Bordenave Designs

May 5, 1992

Mr. Gilbert Aldaz
Re: Zanos Foods, K10/D21A

The subject project was approved for building permit by you on November 26, 1991. Since that time the Owner has found it in his best interest to reorient some of the construction features. The attached plans show the results of that reconfiguration.

GRADING AND DRAINAGE PLAN - DETENTION POND ZANIOS FOODS

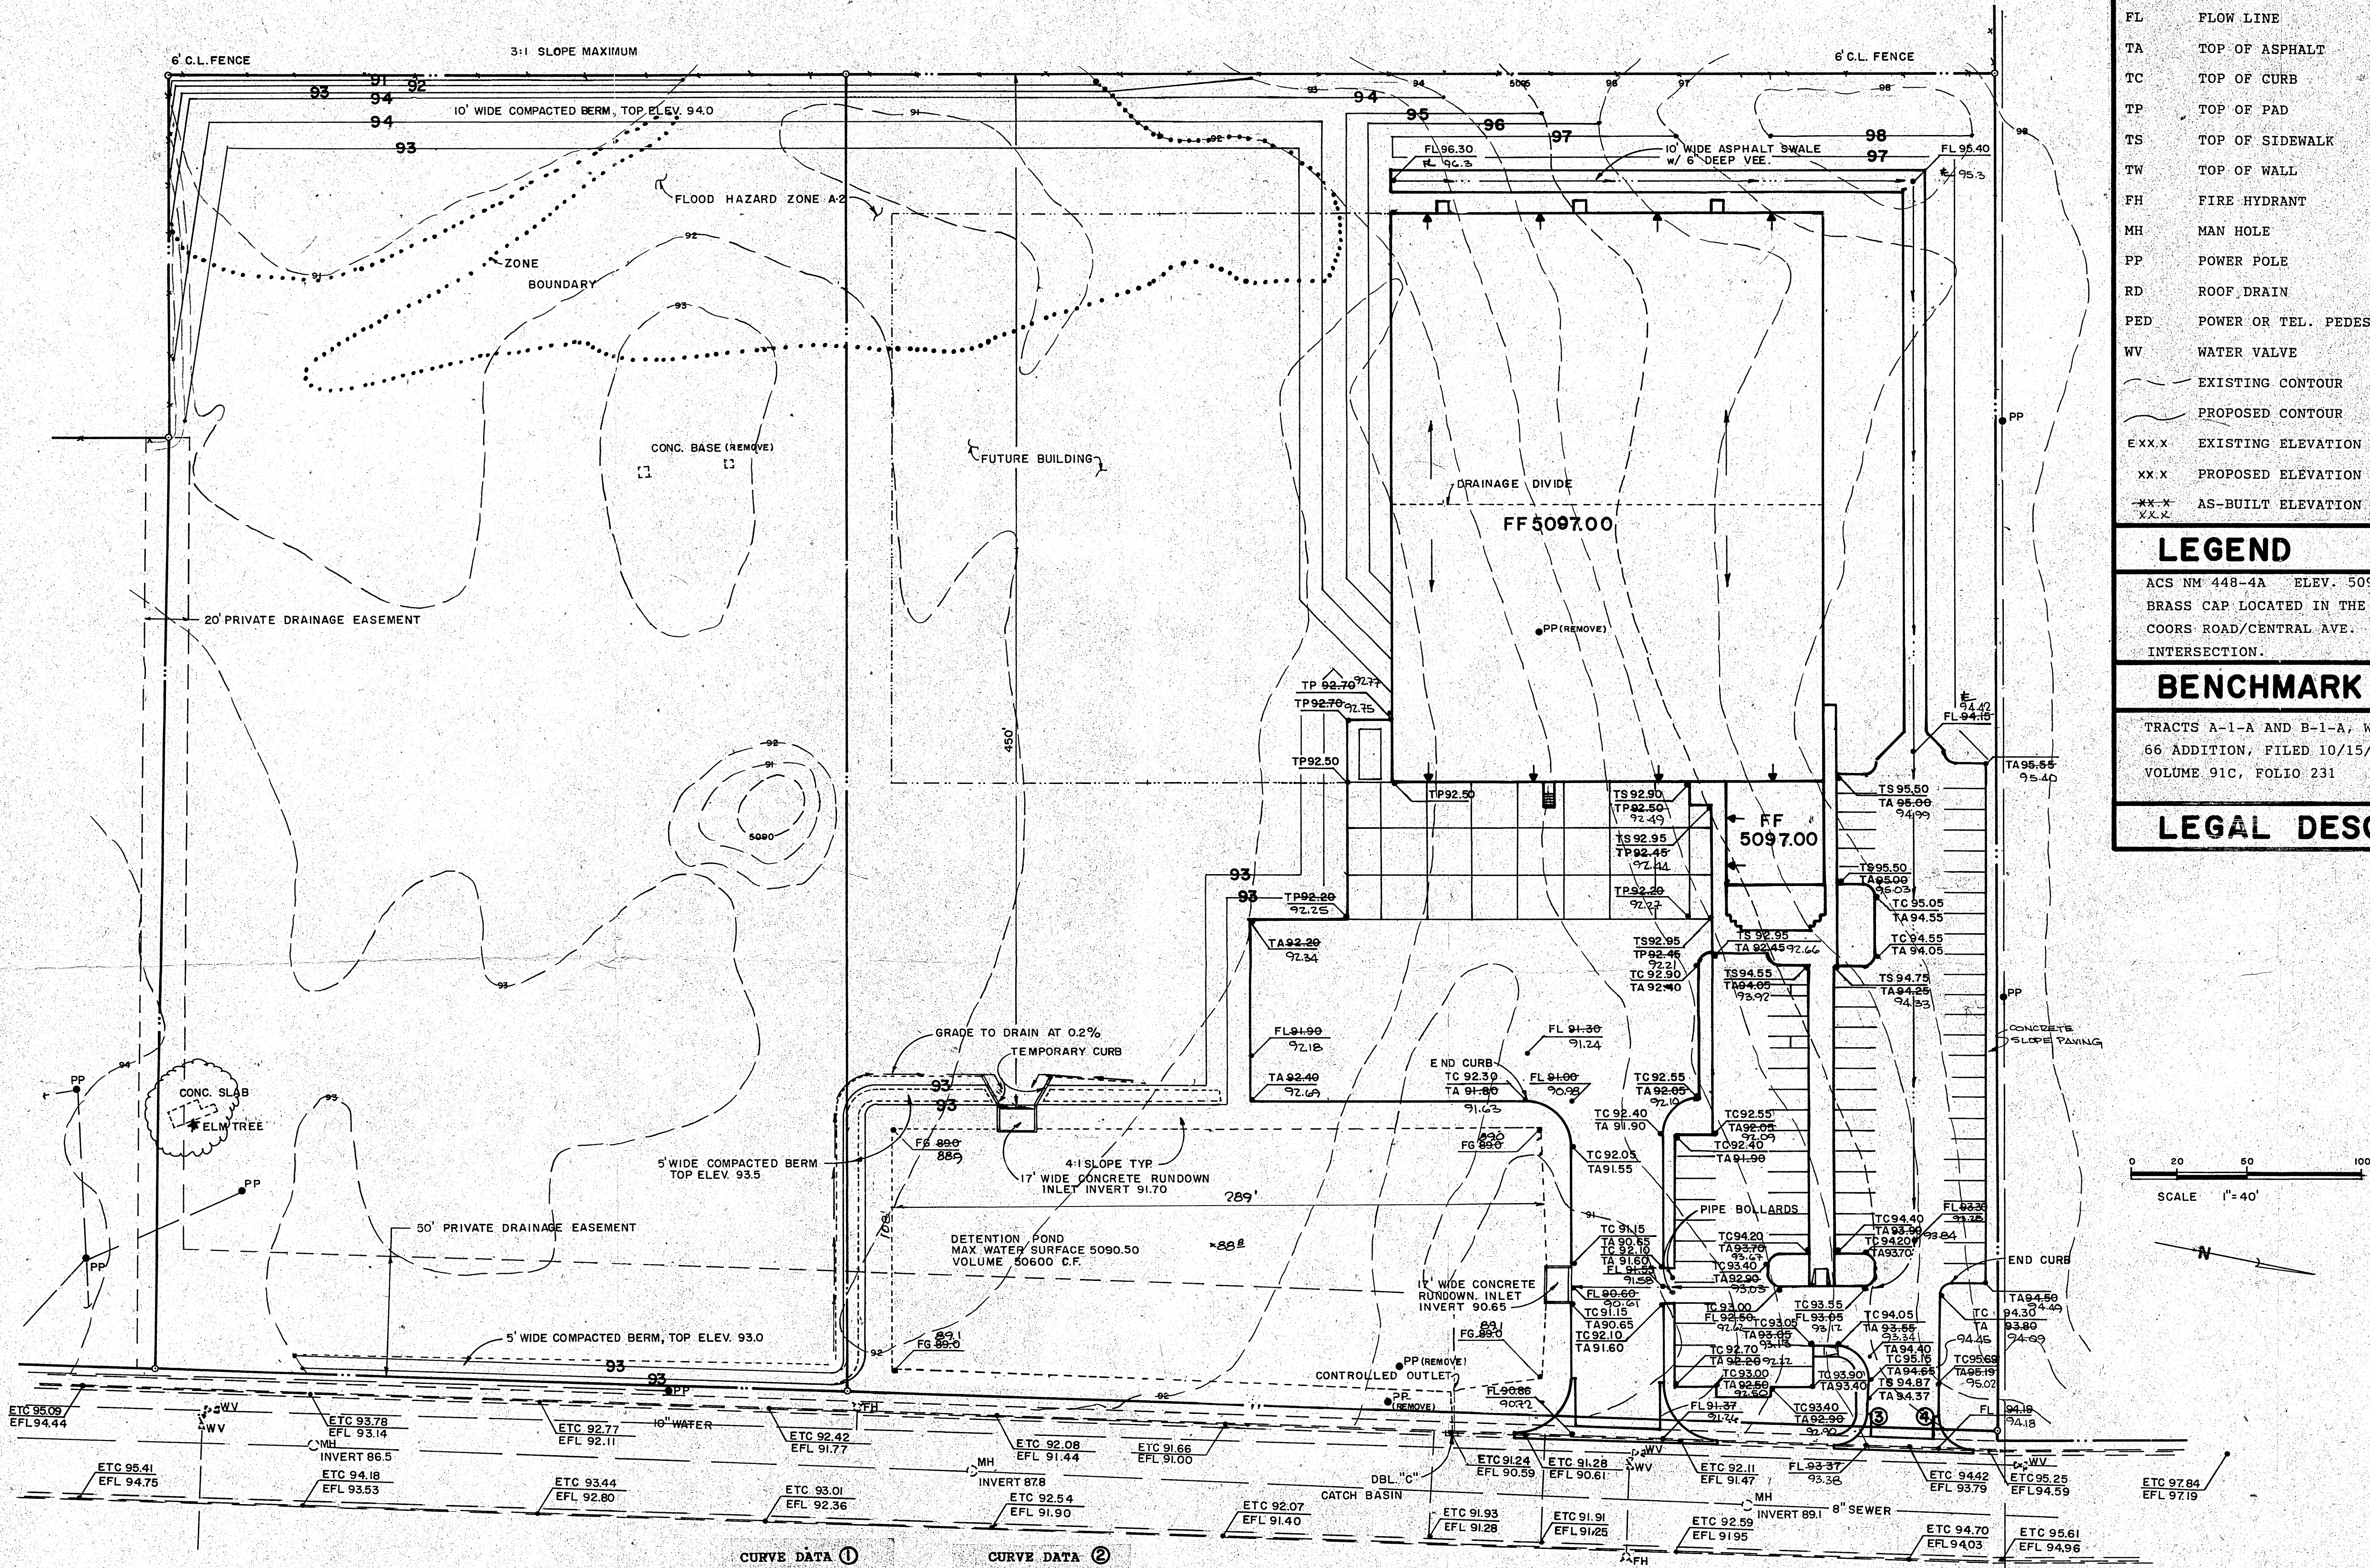
The result of the reconfiguration is positive from a drainage point of view in that the ponds are combined making operation and maintenance of the system much more simple. The drainage entrance to the pond is a better configuration and the resulting pond has more capacity. The original Phase I pond had a volume of 115200 cf and the revised pond has a volume of 125800 cf. The original Phase II ponds had a volume of 49010 cf and the revised pond has a volume of 50600 cf.

The drainage patterns and basins remain as they were in the original plan.
